MR. YNTEMA
(FIRST SPEAKER)

PRESENTATION TO DRB
August 14, 2019

My name is Hess Yntema. I am a lawyer. My address is 215 Gold Avenue SW, Suite 201, Albuquerque, New Mexico, 87102. I represent 13 individuals and the Hope in the Desert Episcopal Church in this matter, who I will refer to as the Neighbors, who object to this project as currently designed. I submitted a letter dated August 7, 2019 to the DRB which I request be placed in the case record if it's not there already. The Neighbors whom I represent also include Steve Wray, an affected landowner whose address is 8505 Tierra Morena Place NE (south of the site), whose name was not in my August 7, 2019 letter. I would like to submit for the record a copy of a letter sent to the DRB by Mr. Wray, and a list of names and addresses of the persons and one entity I represent in opposition to the proposed site plan. A number of these Neighbors I represent own and reside at their homes adjacent to the subject site, on the north side of Tierra Morena Place NE. Please send me notice of filings and the DRB decision in this matter.

1 Site Plan - West
1" = 20'-0"

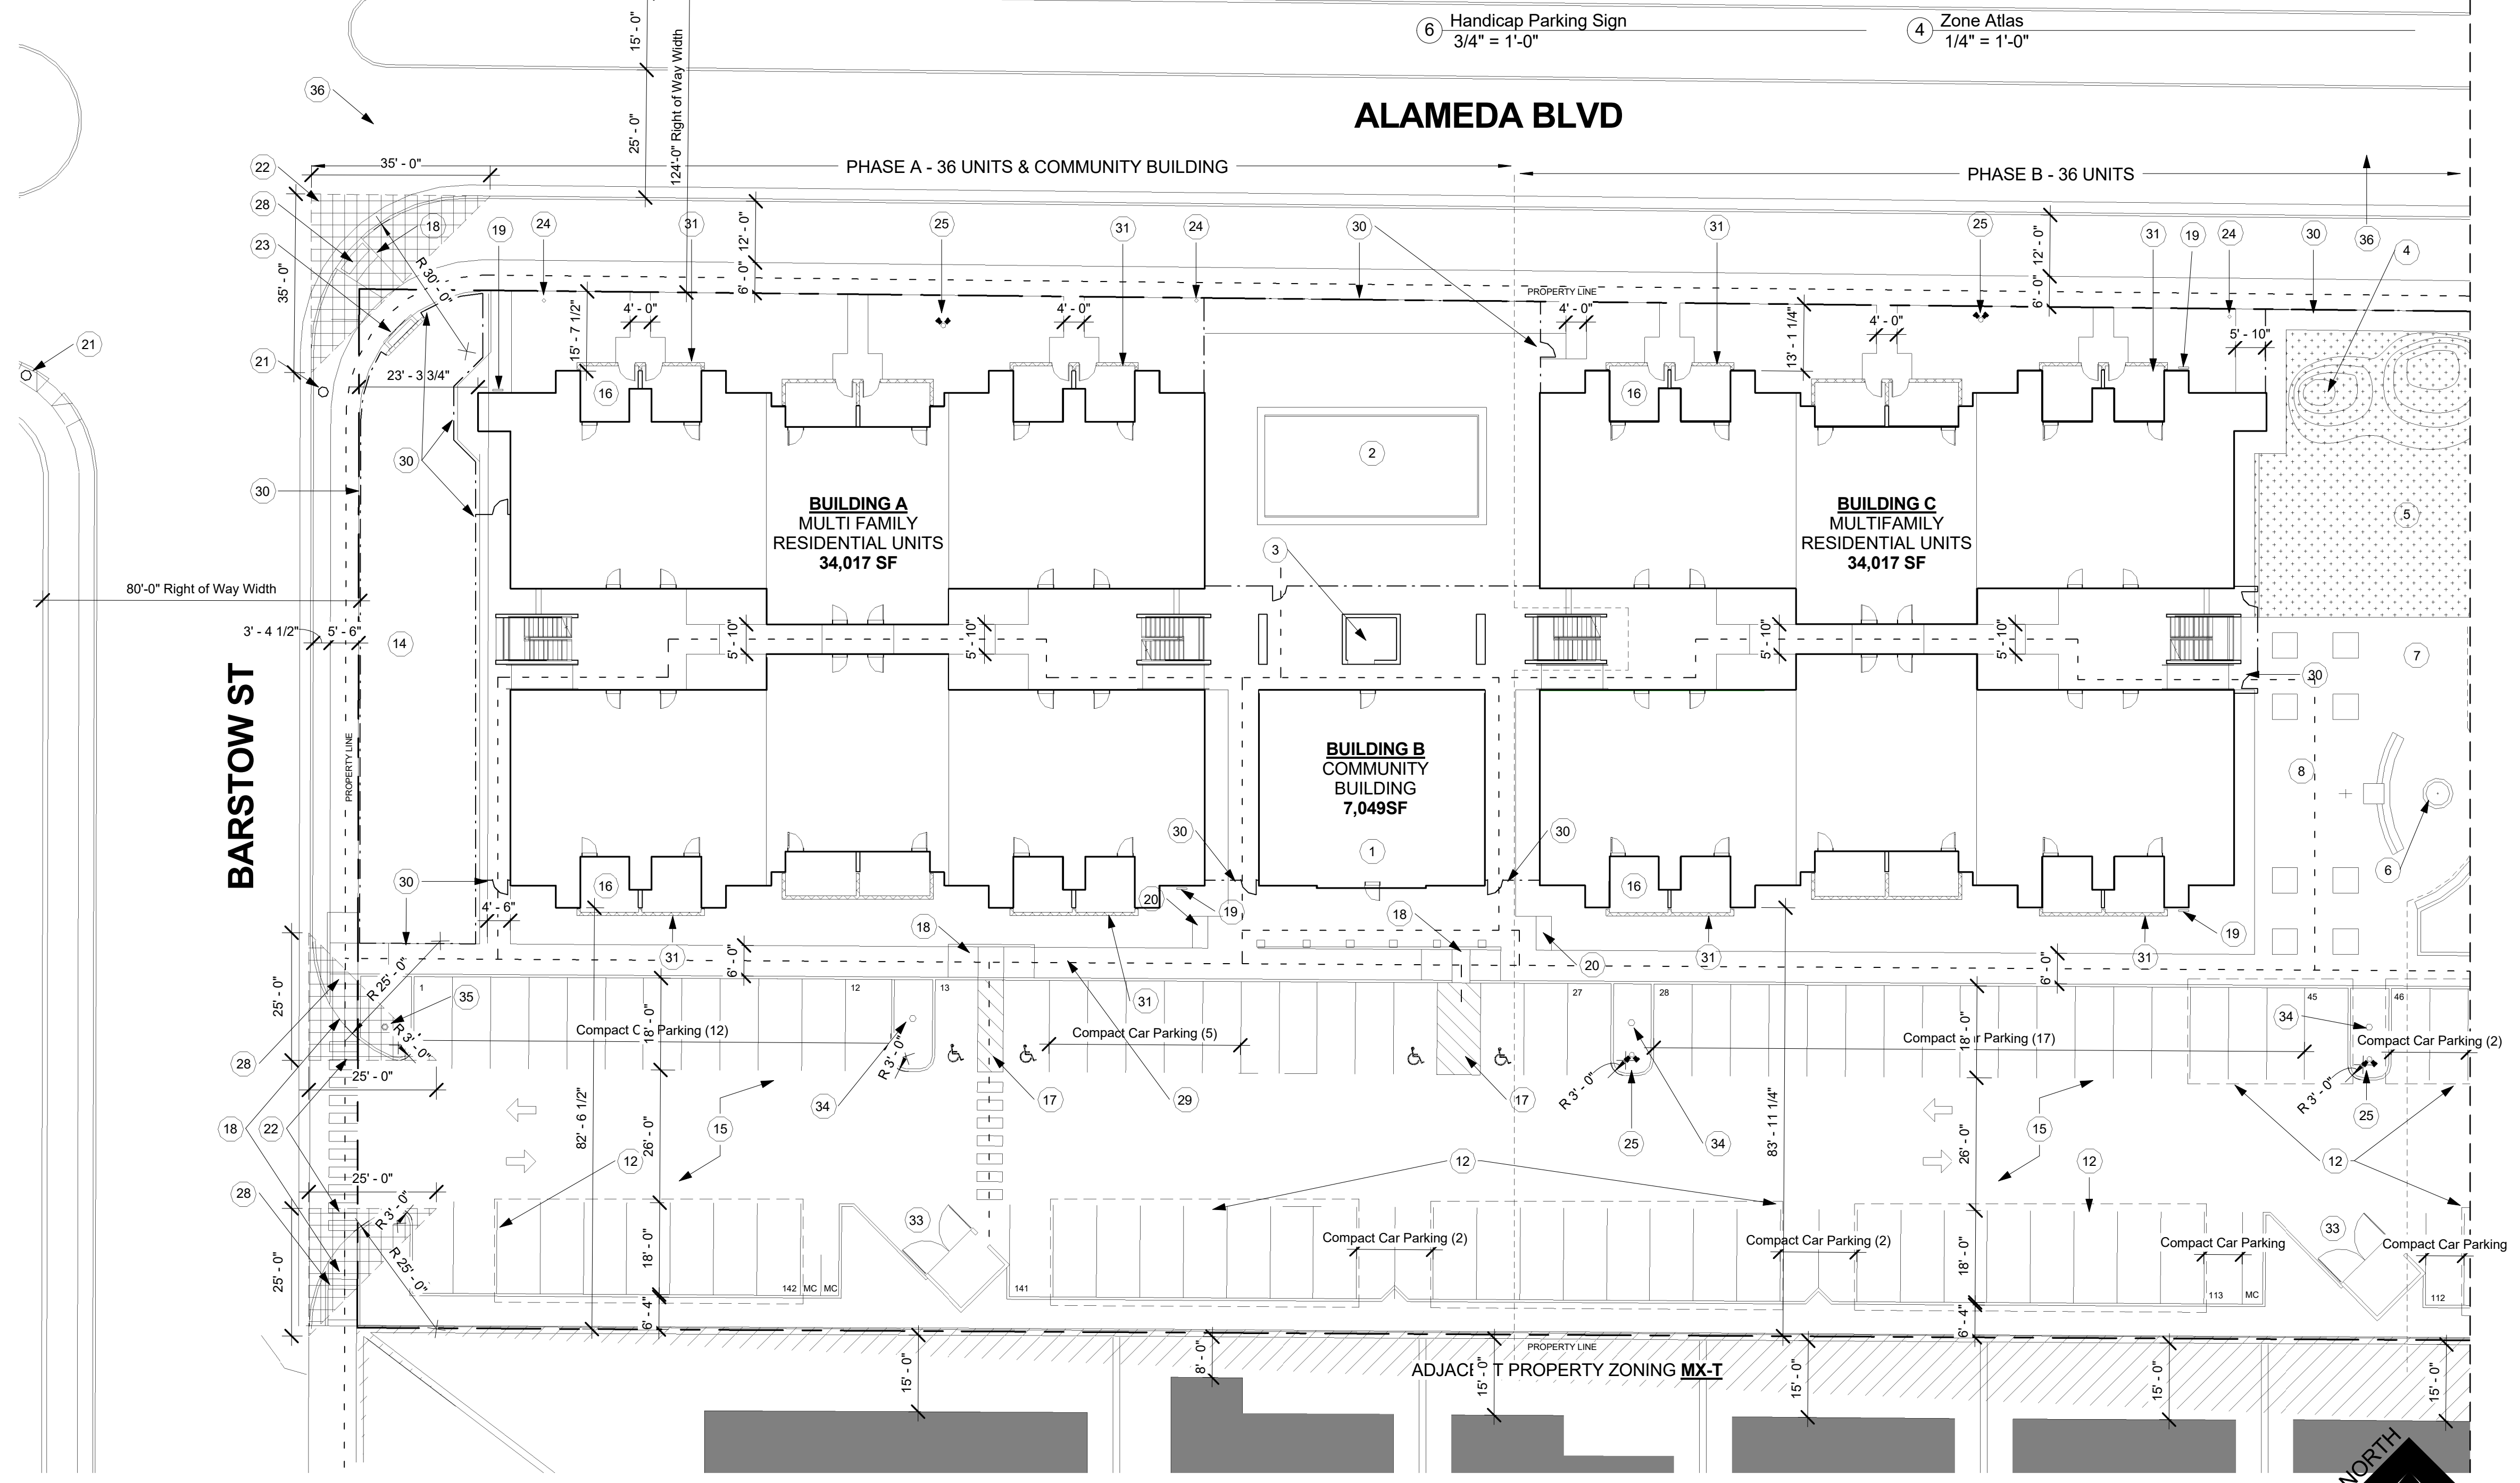
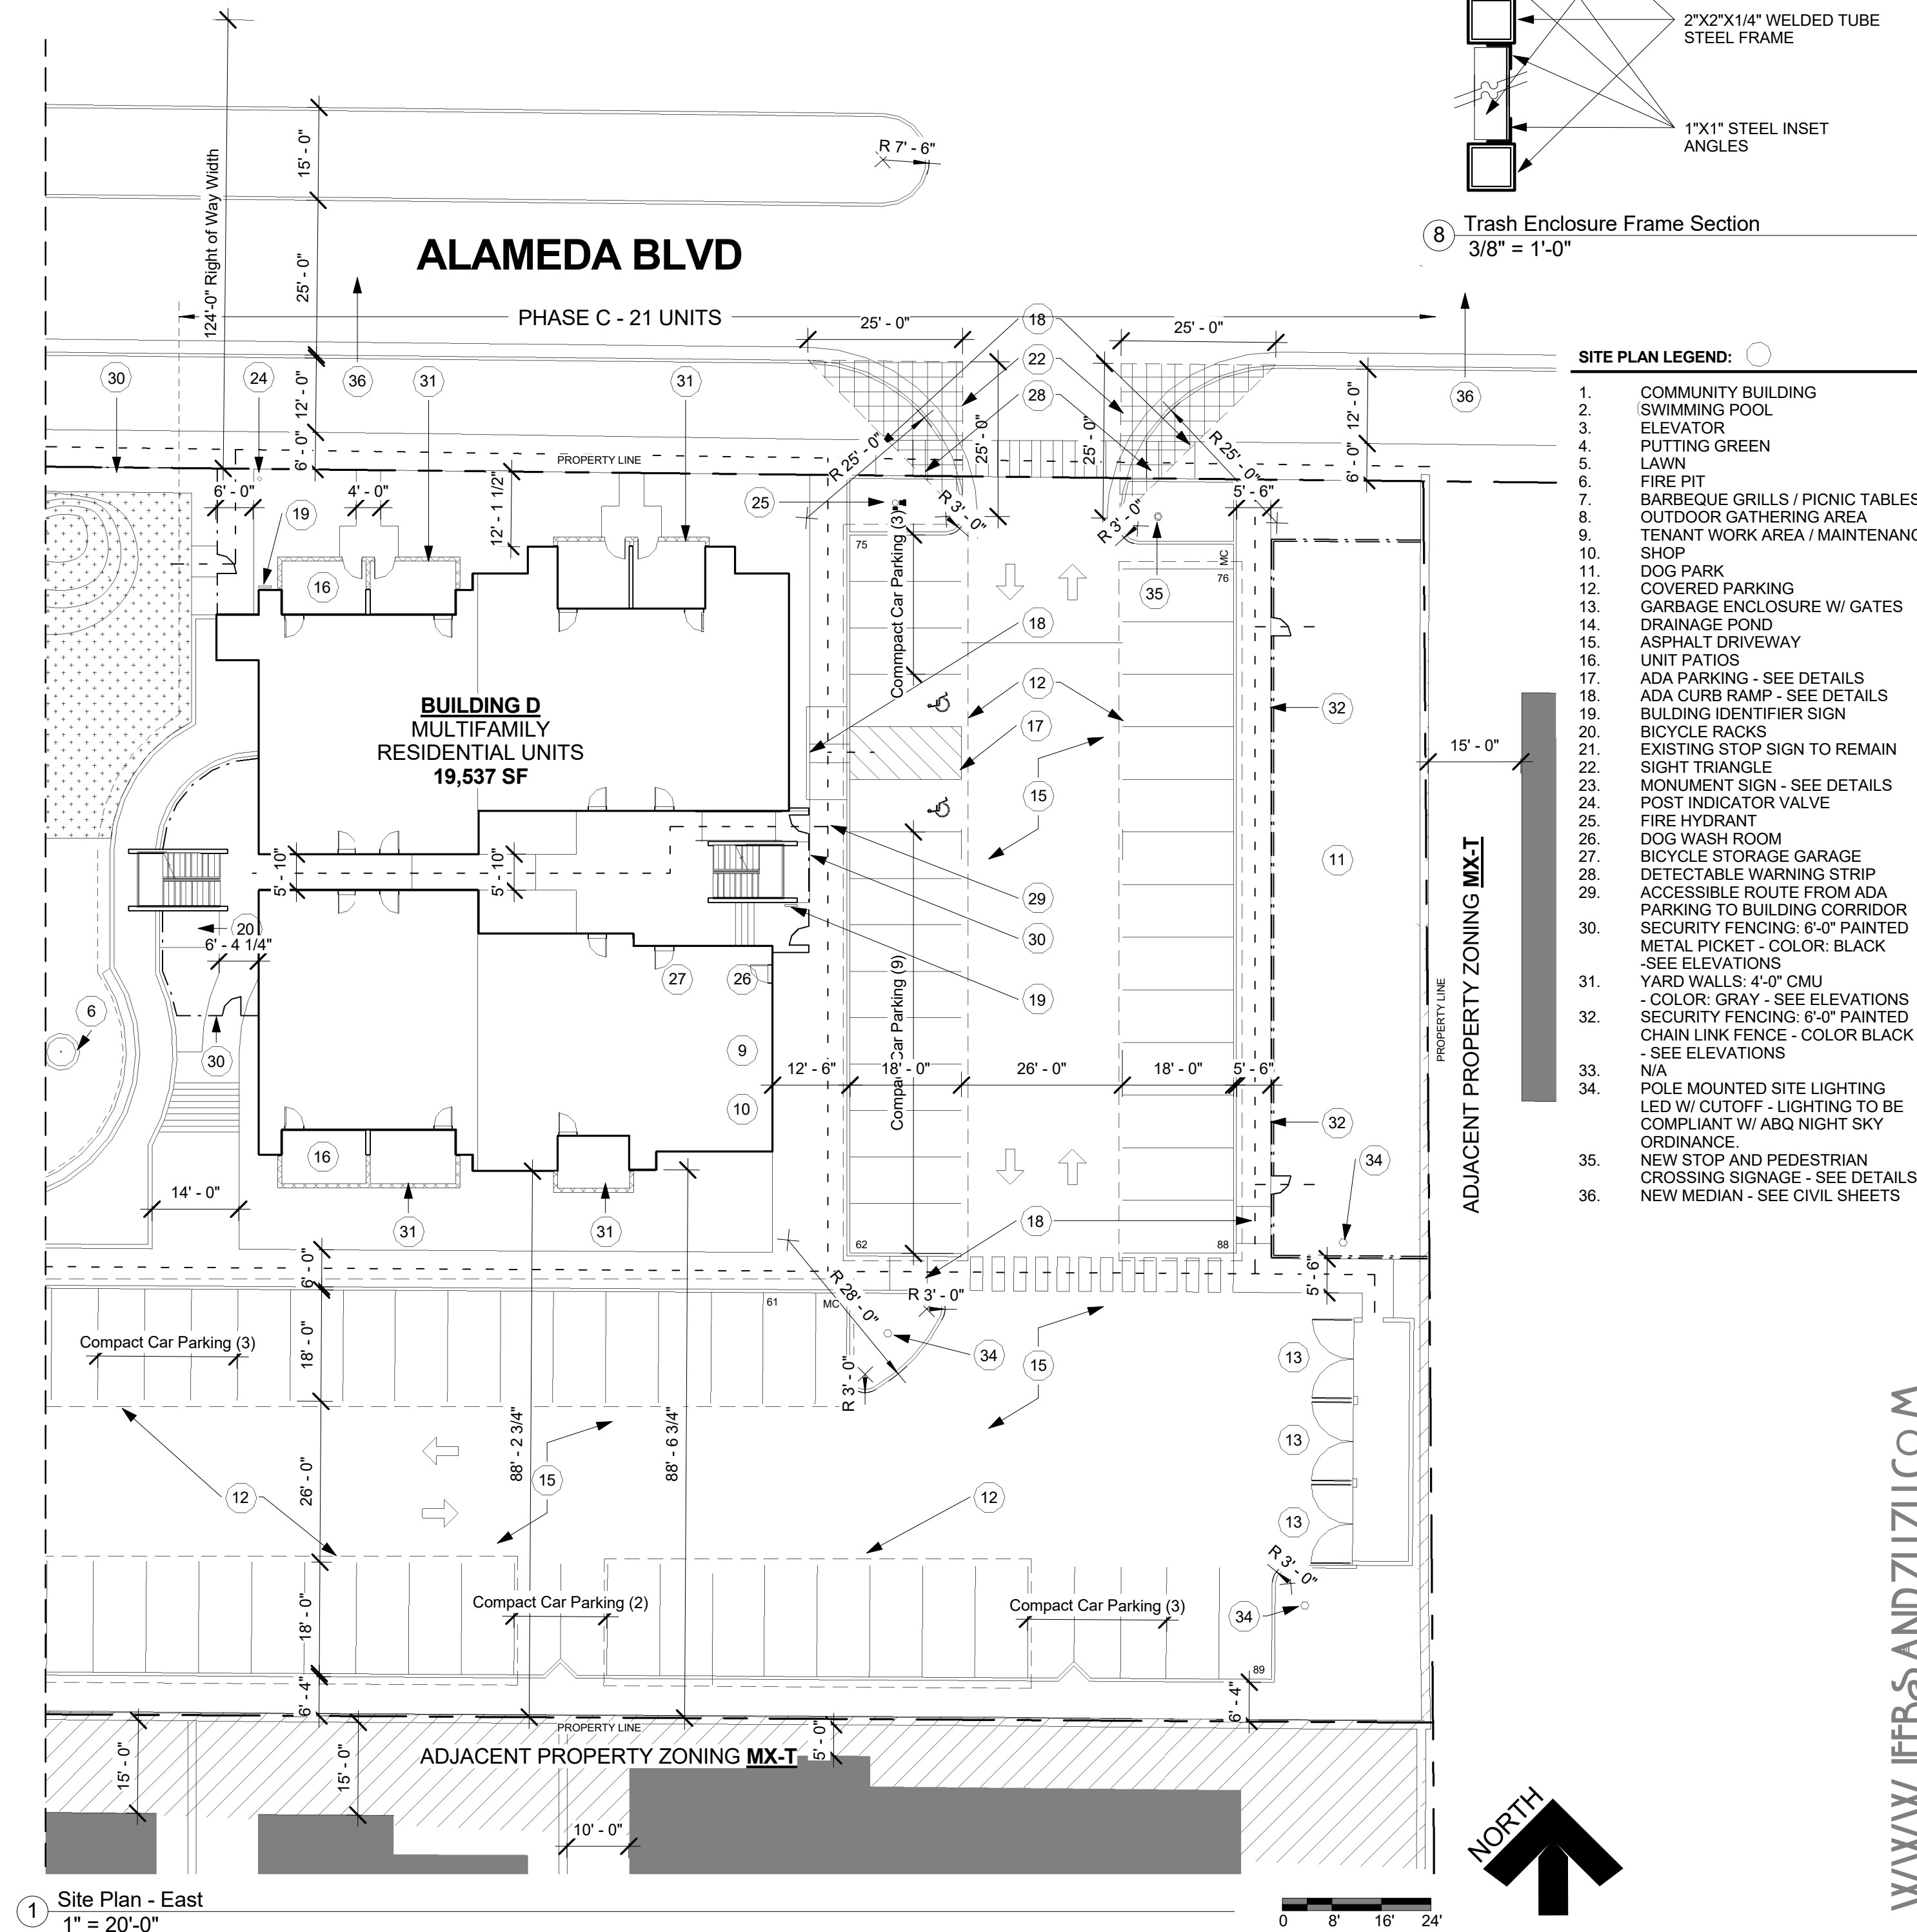
I have several objections to the development. The most pressing objections are the parking, parking structures, lighting and dumpsters that will be adjacent to my house. The wall that separates the development from my house measures 5'9" tall at the location of my house. There is no way that a parking structure of 8 to 10 feet high or more with lighting adjacent to a 5'9" wall will not spill light into my space. In addition placing dumpster adjacent to the wall bordering my back yard is obtrusive. They smell, attract insects and rodents and are unsanitary. Additional objections that I have are the density of the project which does not fit with the overall character of the neighborhood. Commercial buildings just to the East of the proposed development include a pediatrician's office, dental office, church, school and light office space. The proposed 93 unit, 3 story apartment complex is too dense!

I have not received information from the developer regarding an elevation or detail of the parking structure, the layout of the parking, barrier, landscaping, and boundary wall. I have not received information about drainage except the statement it is complicated.

1. **Security** – *The common areas within the site have been secured with an attractive black wrought iron fence that will require key card access;*
2. **Solid Waste** – *Following a meeting with City Solid Waste staff the dumpster locations along the southern landscape buffer will be restricted to recycling only;*

3. **Landscape Buffer** – *Four evergreen trees have been added to the southern boundary and specifically located to provide additional screening for the recycling locations (these trees are in addition to the trees required to meet the minimum standard);*

4. **Lighting** – *A note has been added limiting the lighting under the proposed parking shade canopies to the northern edge of the canopies and that they be night sky compliant down lighting fixtures to prevent light pollution to the neighbors to the south; and*
